**KIRKLEES METROPOLITAN COUNCIL
INVESTMENT & REGENERATION SERVICE**

**DELEGATED DECISION FOR APPLICATION FOR CERTIFICATE OF
LAWFUL DEVELOPMENT**

Reference no.: 2023/CL/93435/W

Description: Certificate of lawfulness for proposed erection of
rear dormer and loft conversion

South Elevation

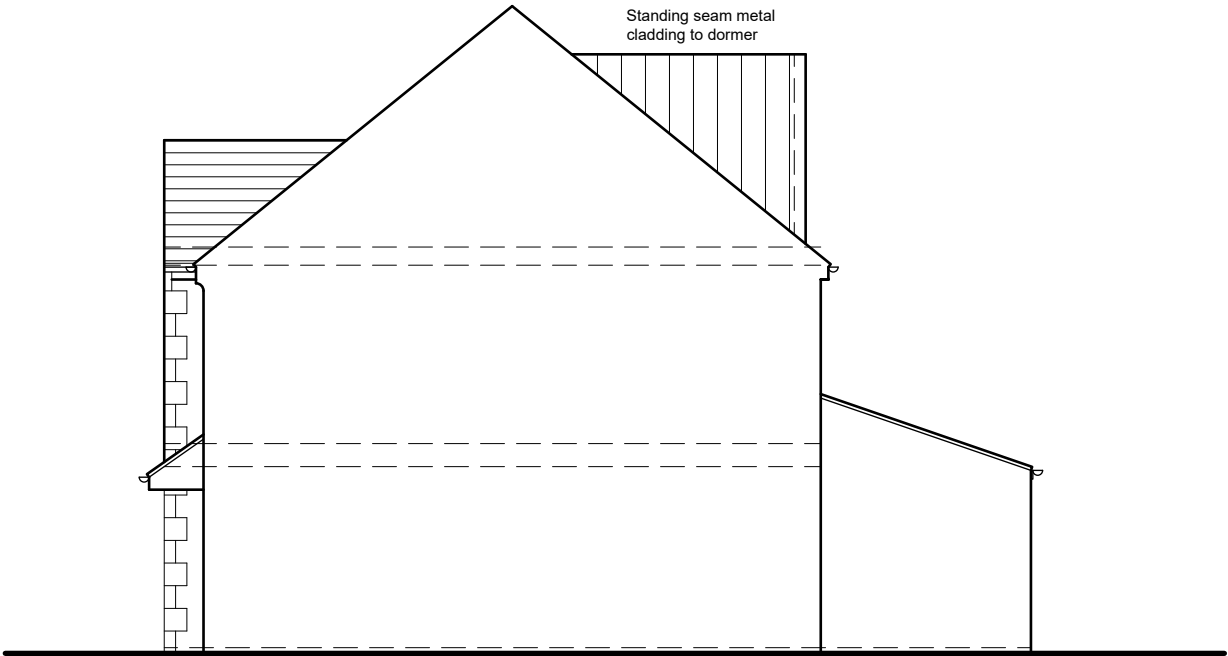
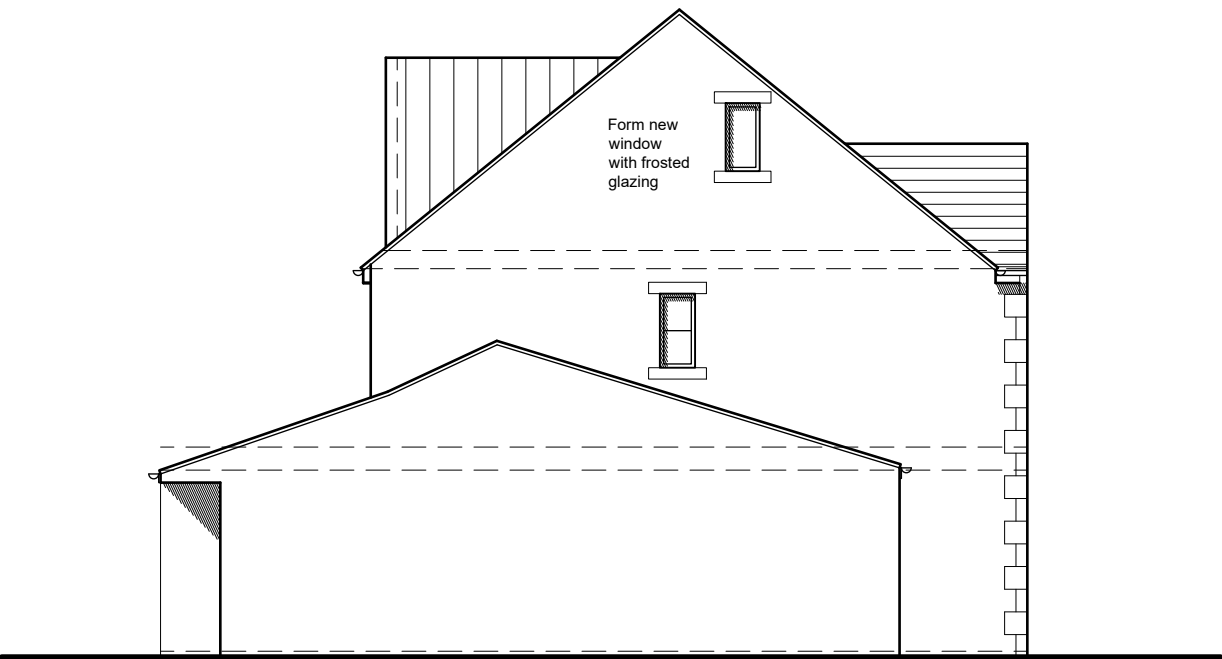
Comment *As can be seen from the elevations, no part of the dwellinghouse would exceed the height of the highest part of the existing roof.*

Comment The window in the side elevation will be glazed and non-opening.
